ADDENDUM #3 Dated August 9, 2004

East End Elementary School  
Portland, Maine

City of Portland BID # 8704

STEPHEN BLATT ARCHITECTS  
P.O. BOX 583  
10 DANFORTH STREET  
PORTLAND, ME 04112-0583

201+00  
201+50  
OFFSITE STORM DRAIN PROFILE NS-A  
SCALE: 1"=30' HORIZ., 1"=3' VERT.

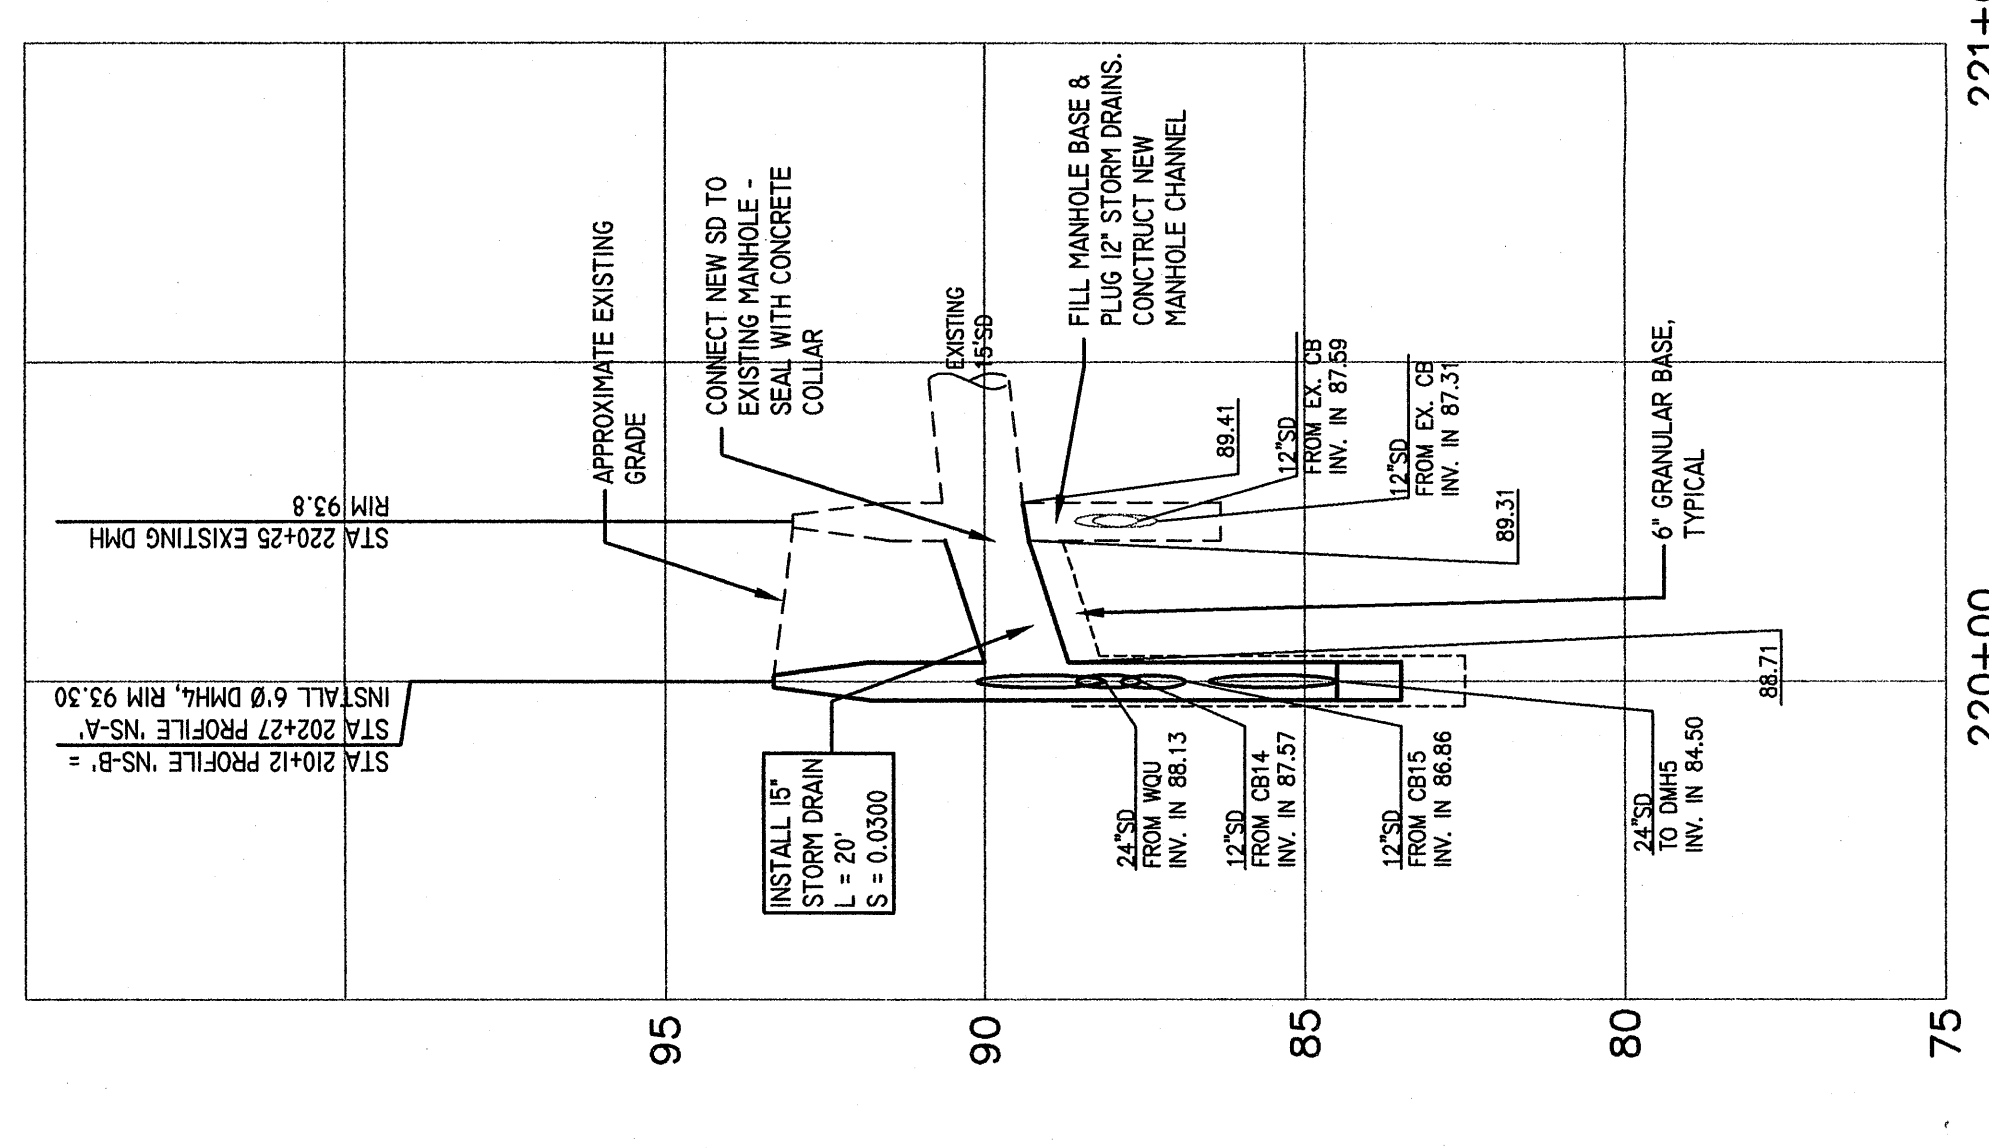
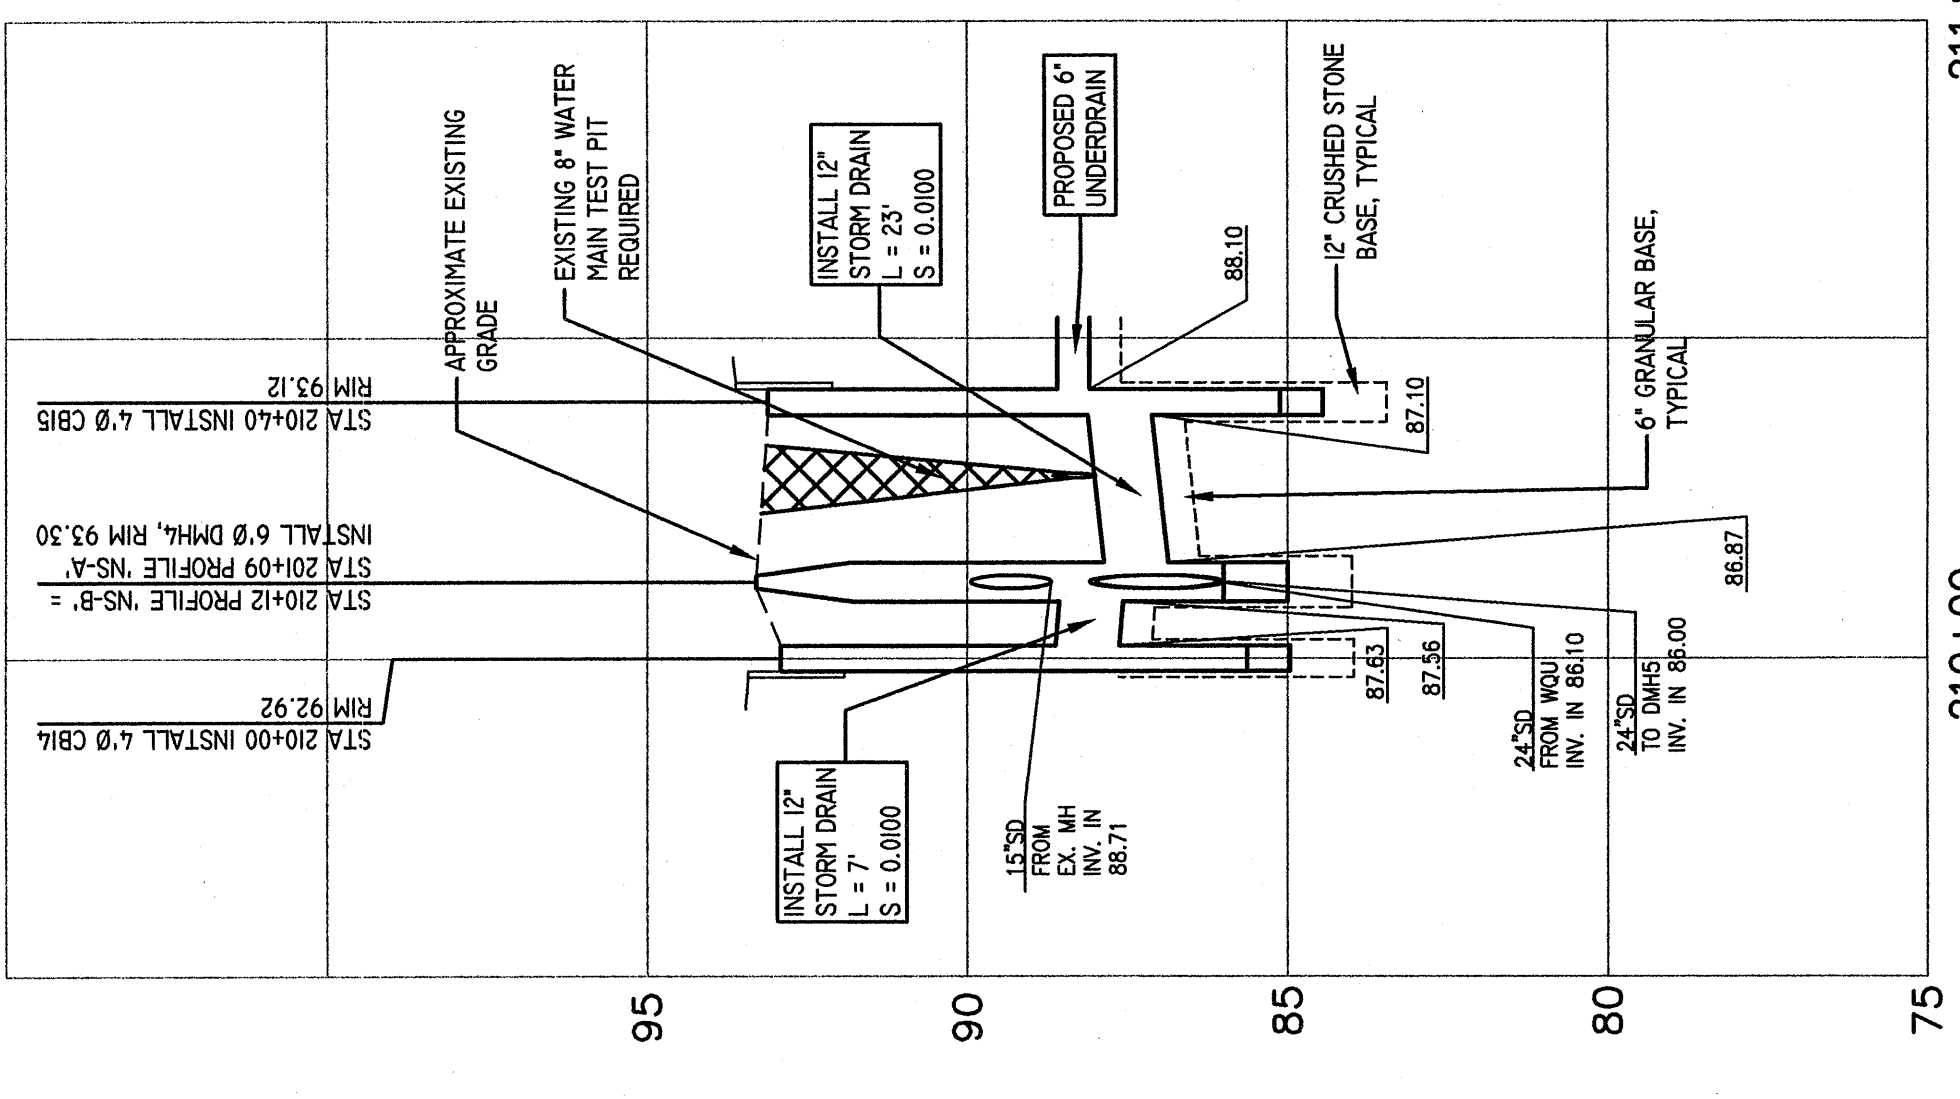
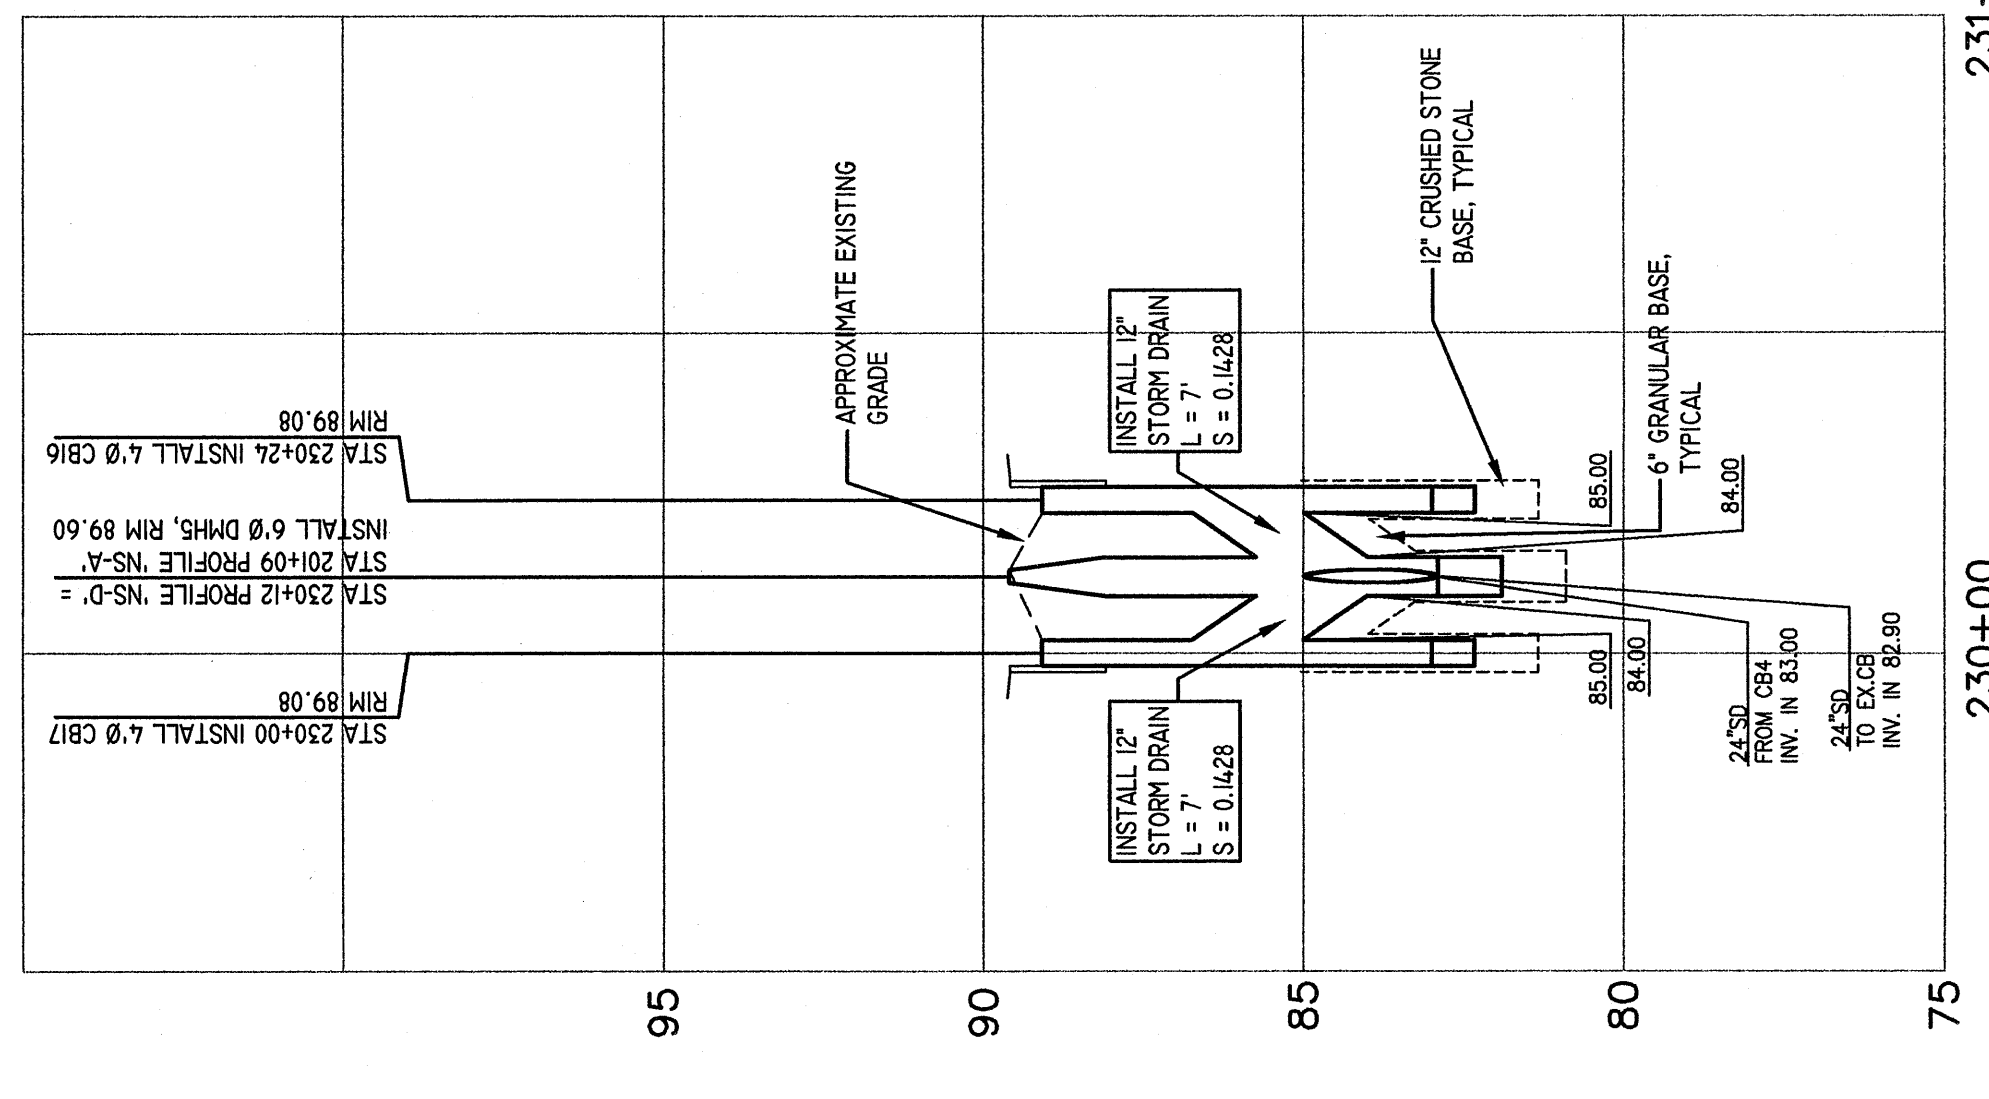
A potential bidder inquired about the size of inlets. The profiles identify the size of the inlets, catch basins, and manholes.
